Our Ref: FP/57/19/PL
Your Ref:

Town & Country Planning Act 1990 (as amended)
Town and Country Planning (Development Management Procedure) (England) Order 2015
Application for Planning Permission

Development Conversion existing restaurant (A3 Food & Drink) & flat into 2 No. flats. This application affects the character & appearance of the Felpham Conservation Area.

Location Ye Old Malt House Restaurant Waterloo Road Felpham

PROPOSED REAR ELEVATION

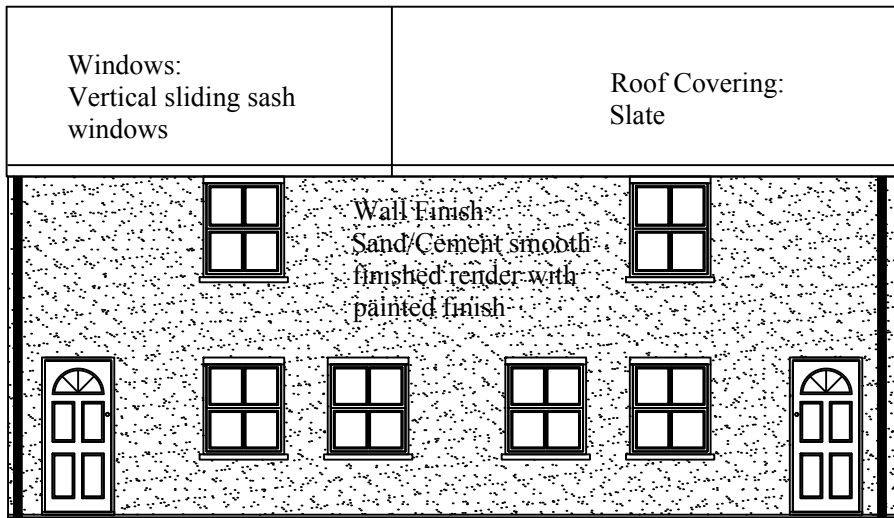
The proposed first floor plan and the rear elevation do not accord. Please amend accordingly.

PROPOSED SOUTH ELEVATION

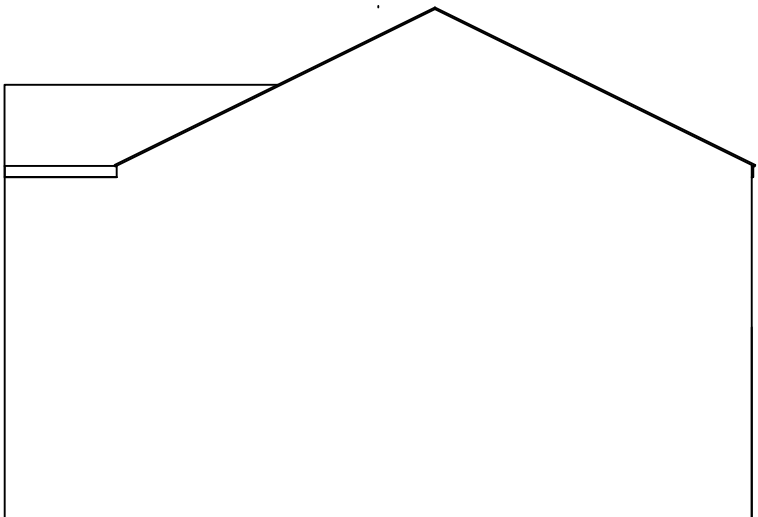
The proposed ground floor plan and south elevation do not accord. Please amend accordingly.
